**WELWYN HATFIELD BOROUGH COUNCIL
EXECUTIVE DIRECTOR - PLANNING, PUBLIC PROTECTION AND GOVERNANCE**

Application No: 6/2019/2571/VAR
Location: 101 Brookmans Avenue, Brookmans Park, Hatfield, AL9 7QG
Proposal: Variation of condition 11 (approved drawings) on planning permission 6/2019/0434/FULL
Officer: Mr David Elmore
Recommendation: Granted

6/2019/2571/VAR

Drawing Title  
 HOUSE 5

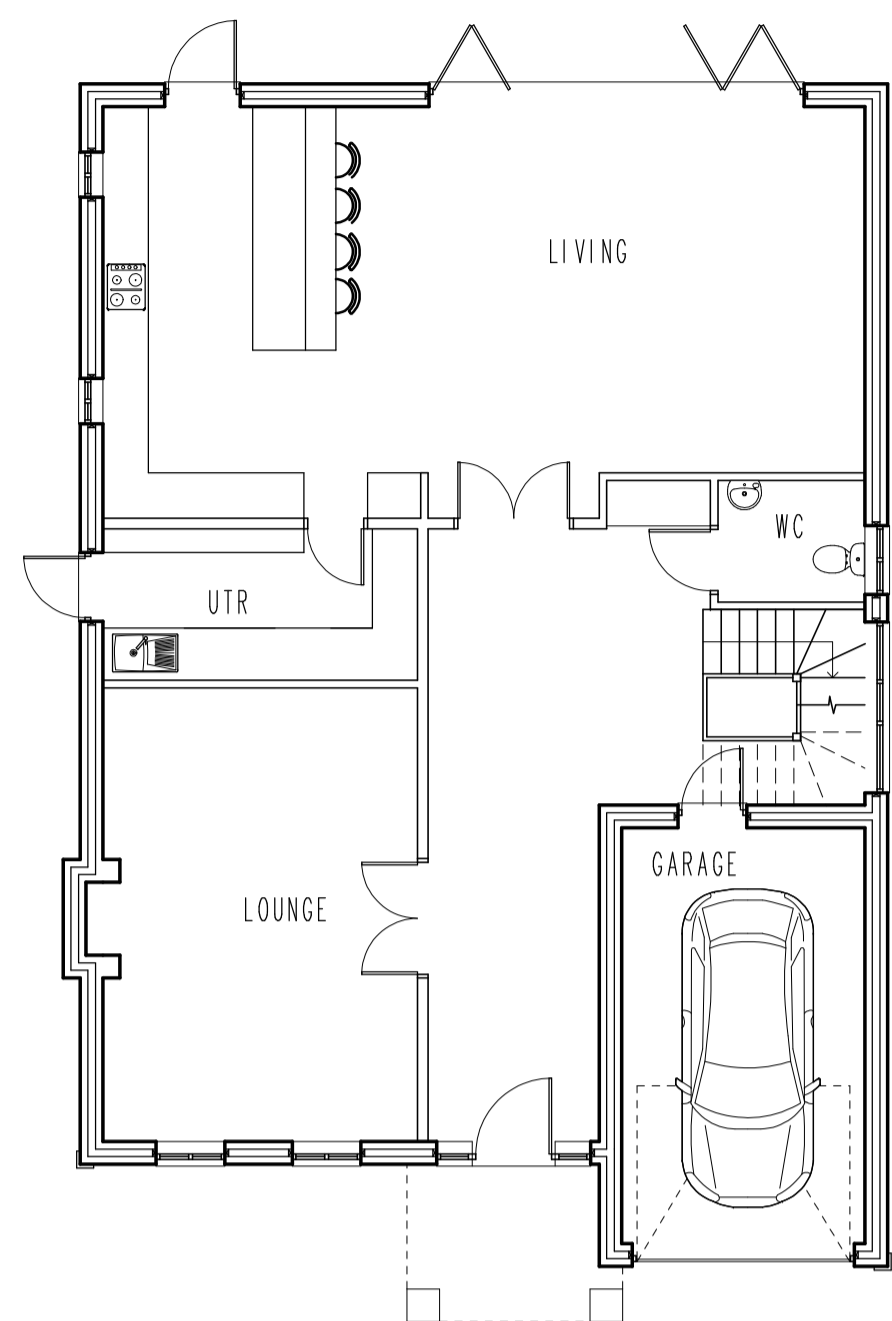
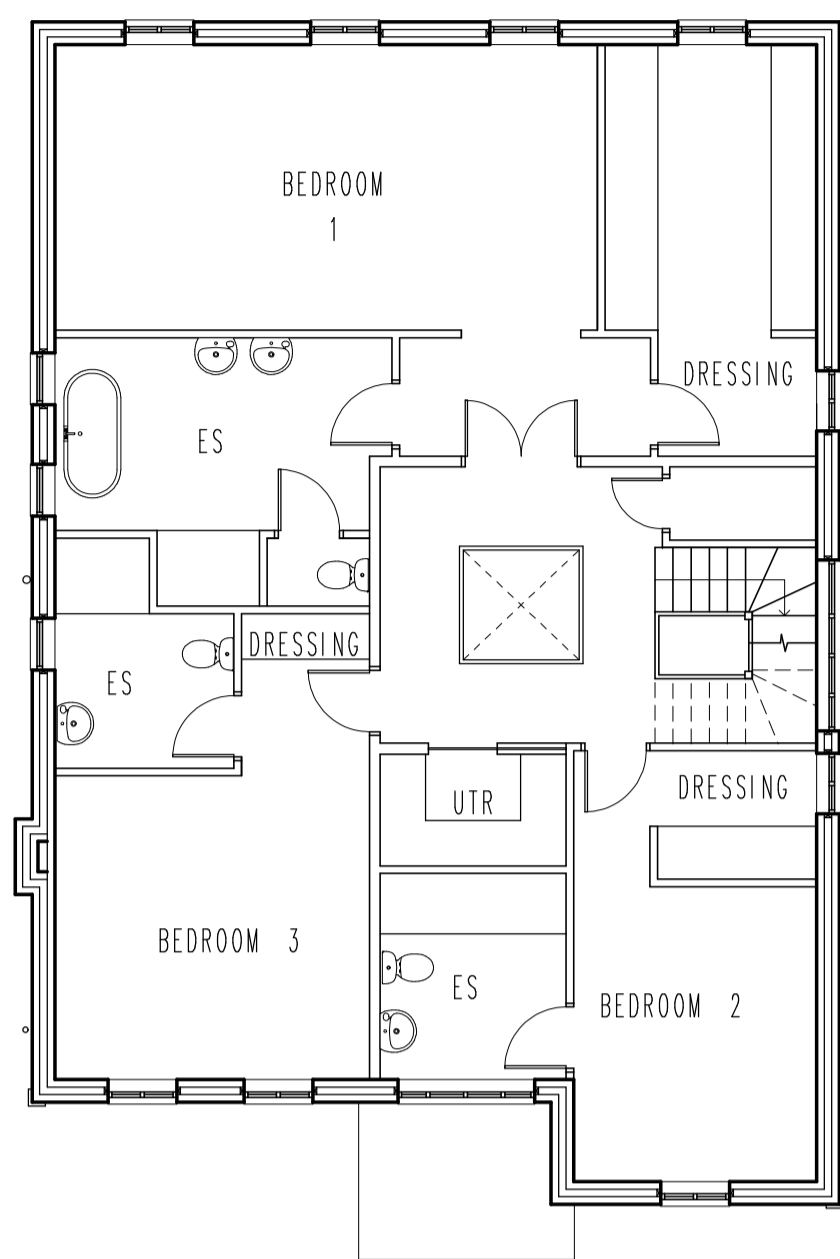
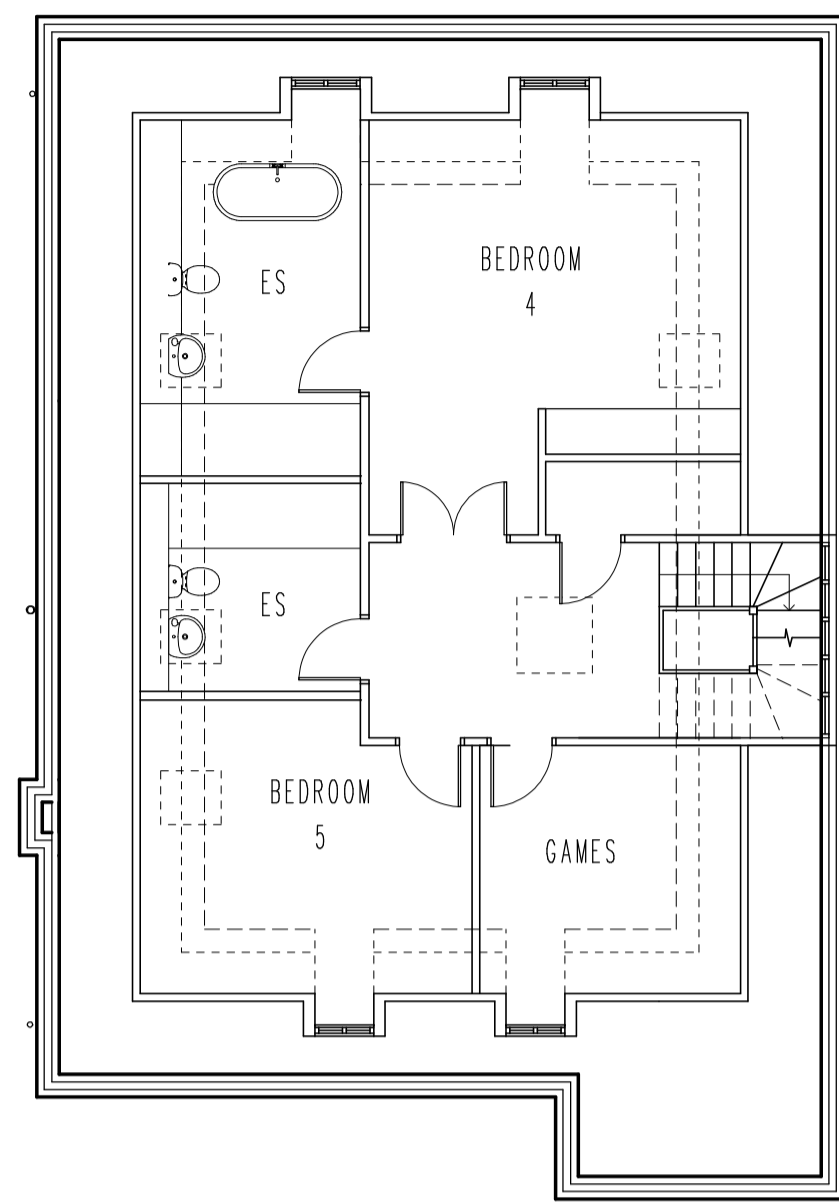
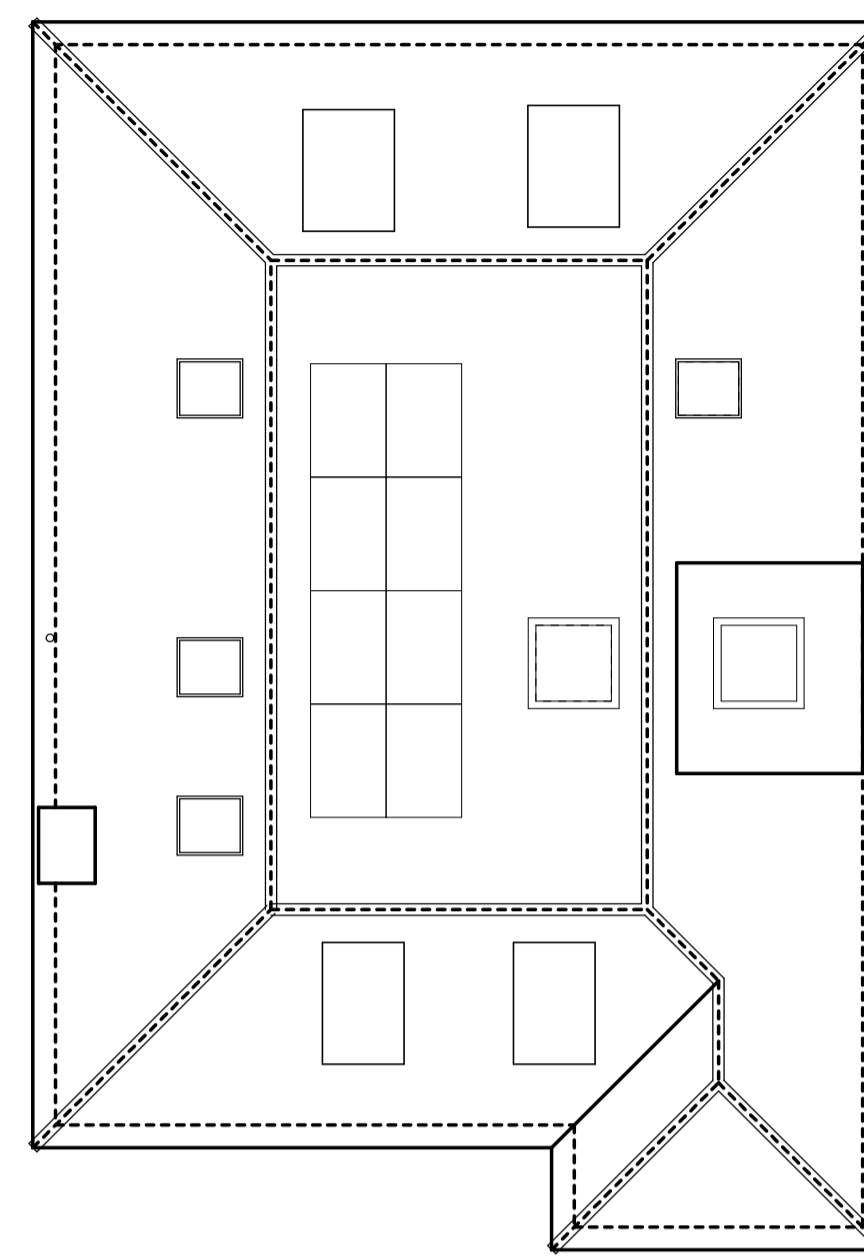
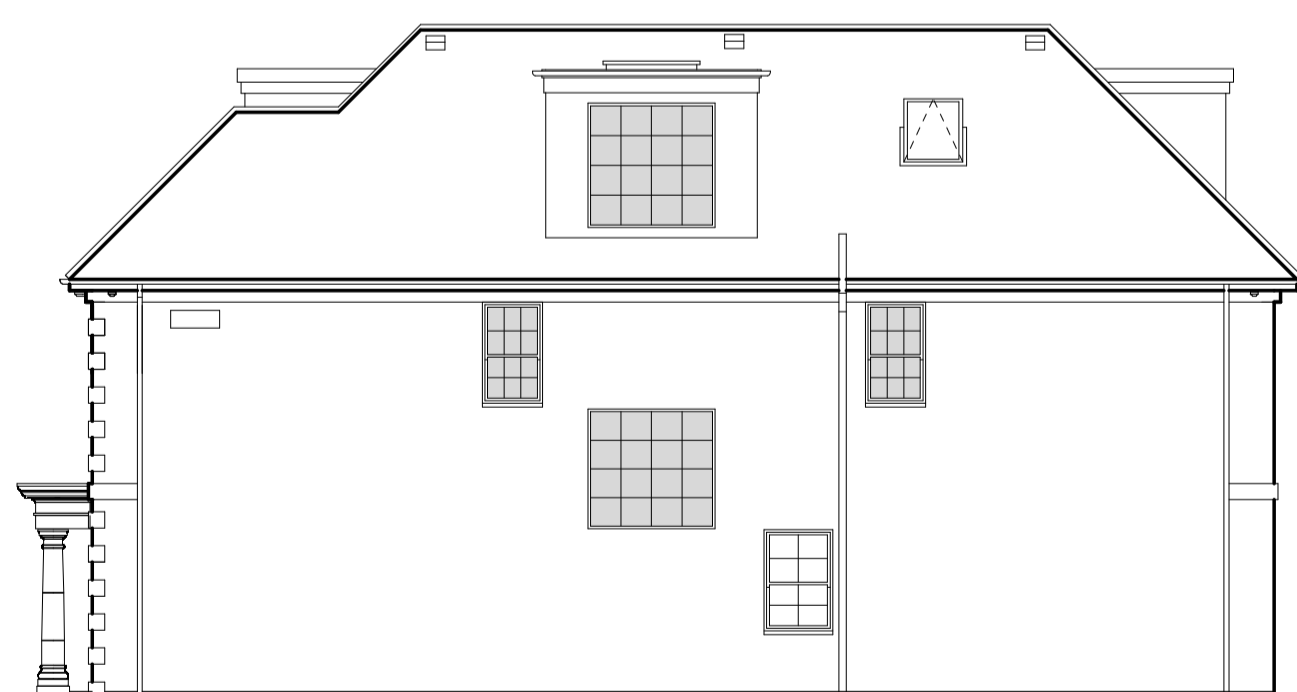
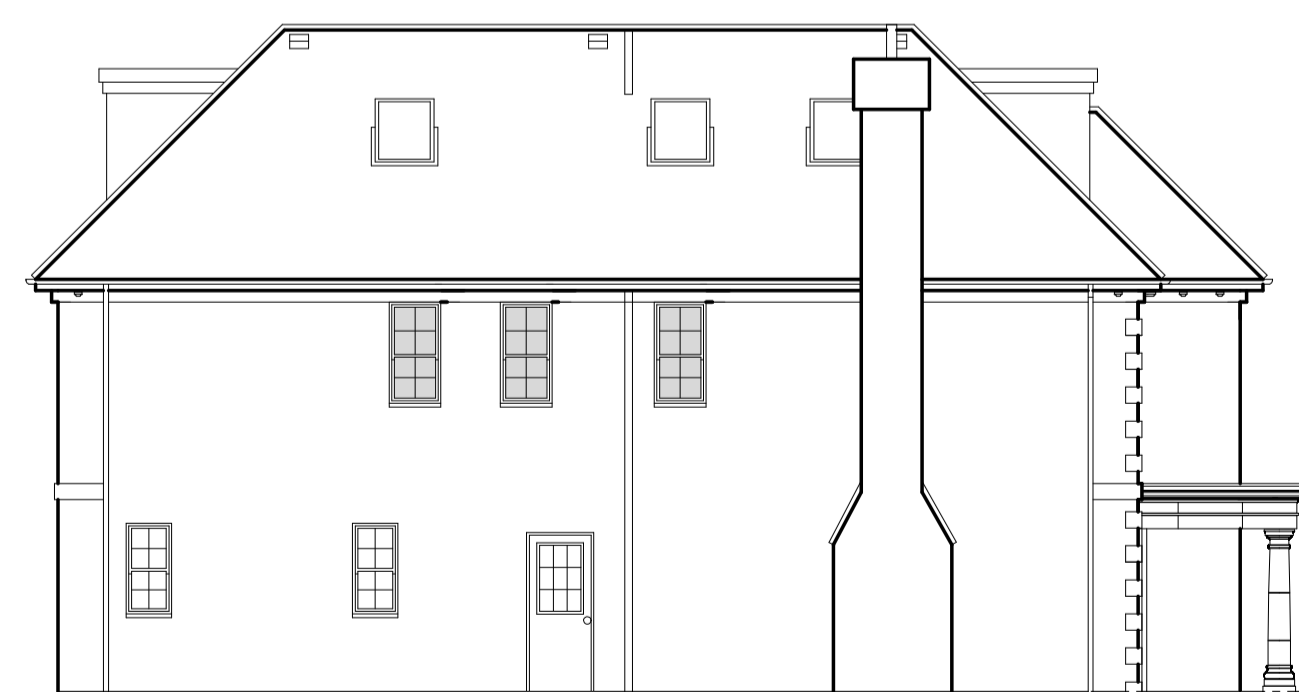
Context	
Site and Application description	<p>This application seeks a variation to condition 11 (approved plans) of planning permission: 6/2019/0434/FULL. The proposed changes to the approved plans include:</p> <ul style="list-style-type: none"> - Increase in size of side dormer serving staircase of Houses 3, 4 & 5. Width increased by 0.6 metres; - One parking space removed from front driveway of Houses 3, 4 & 5; - Study of Houses 3, 4 & 5 replaced with a garage; and - Fenestrations details of Houses 3, 4 & 5 amended
Constraints (as defined within WHDP 2005)	<p>PAR - PARISH (NORTH MYMMS) Wards - Brookmans Park & Little Heath</p>
Relevant planning history	<p>Application Number: 6/2019/3006/COND Decision: Under consideration Decision Date: Proposal: Submission of details pursuant to condition 2 (crown roof details) and condition 3 (biodiversity and external lighting) on planning permission 6/2019/0434/FULL</p> <p>Application Number: 6/2019/2313/FULL Decision: Under consideration Decision Date: Proposal: Erection of six dwellings following demolition of existing buildings</p> <p>Application Number: 6/2019/2155/COND Decision: Part Approved / Part Refused Decision Date: 24 October 2019 Proposal: Submission of details pursuant to condition 1 (Materials), 2 (Crown Roof) and 3 (Biodiversity and Lighting) on planning permission 6/2019/0434/FULL</p> <p>Application Number: 6/2019/0434/FULL Decision: Granted</p>

<p>Would the development provide / retain sufficient parking?</p> <p><input checked="" type="checkbox"/> Yes <input type="checkbox"/> No</p> <p>Comment: Whilst Houses 3, 4 & 5 would lose a parking space within the front driveway, each of these dwellings would now benefit with an integral garage to serve one car. As such, there would be no net loss of on-site parking provision.</p>
<p>Any other considerations</p> <p><i>Landscaping</i></p> <p>The extension of the driveways reduces a small amount of landscaping by the fronts of plot 3, 4 & 5 and boundary landscaping to Houses 1 & 2 is increased. Such changes are considered minor. An acceptable landscaping layout would remain.</p> <p><i>Re-imposition of remaining conditions subject to planning permission 6/2019/0434/FULL</i></p> <p>A successful application to amend condition 11 would result in the issue of what would be in effect a new planning permission, sitting alongside the original permission. To assist with clarity decision notices for the grant of planning permission under section 73 should also repeat the relevant conditions from the original planning permission, unless they have already been discharged.</p> <p>Condition 1 (external materials) of planning permission 6/2019/0434/FULL has been discharged under application 6/2019/2155/COND. The approved external materials would be listed in a varied condition if this section 73 application were to be approved.</p> <p>All other conditions of planning permission 6/2019/0434/FULL remain relevant and would be re-imposed if this section 73 application were to be approved.</p>
